## DECISION DELEGATED TO HEAD OF PLANNING

**Application No:** H09-0786-26      **Applicant:** Wrights Properties Ltd

**Proposal:** Demolition of existing buildings & Erection of 5 no 3 bedroom dwellings, including parking & upgrading access

**Location:** 6-10 Park Road Holbeach Spalding

LANDSCAPING, FENCING & TREE PLANTING SCHEME

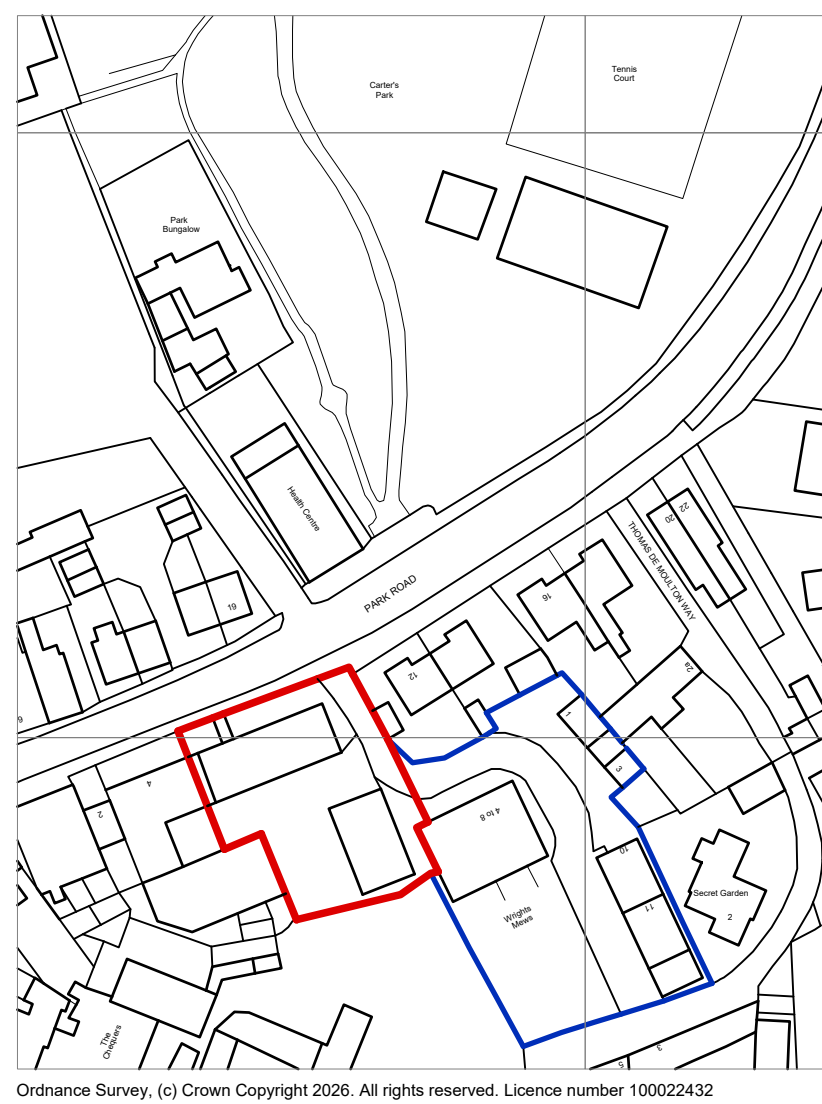
The proposal seeks to demolish the existing buildings within the site and to construct a terrace of 3 dwellings near the site frontage, and 2 semi-detached dwellings to the rear. The 3 dwellings near the site frontage would be set behind front gardens, including some areas of planting and 1.2m high black iron railings.

3 parking spaces are proposed next to the building and due to their positioning, they would be relatively prominent when viewing the site. Ideally, the parking spaces would be located to the rear of the site.

2 dwellings are also proposed at the rear of the site and these dwellings would also measure 8.8m in height. The dwellings are proposed to face to the north-east of the site at a diagonal angle. The 2 dwellings comprise a backland form of development and often it is considered that backland development should be subservient in height, scale, mass and form to the surrounding frontage buildings. In this case, the dwellings would be the same height as the frontage dwellings and overall, it is considered that the dwellings would not be of a subservient or a suitable scale given the backland position of the site. Furthermore, the orientation of the dwellings is considered to be out of keeping for the area.

Overall, the plot layouts are considered to be cramped and this is evident from the relatively small gardens that are proposed. It is recognised that the proposal seeks to redevelop previously developed land within a relatively central position within Holbeach and as such, space is likely to be more constrained than a greenfield site elsewhere within the town. However, it is nonetheless considered that the site layout is cramped and results in an overdevelopment of the site, representing a conflict with Policies 2 and 3 of the Local Plan and Policy DP3 of the NPPF.

The site layout shows 1 parking space per dwelling within the site. Based on the recommendations of Appendix 6, there should be 2 parking spaces per dwelling and as such, there is considered to be a conflict with Policy 36. Notwithstanding this, LCC's highways team consider that the lower level of car parking can be accepted in this case as the site is considered to be within an accessible location where day-to-day facilities and services can be reached by walking, cycling and public transport.
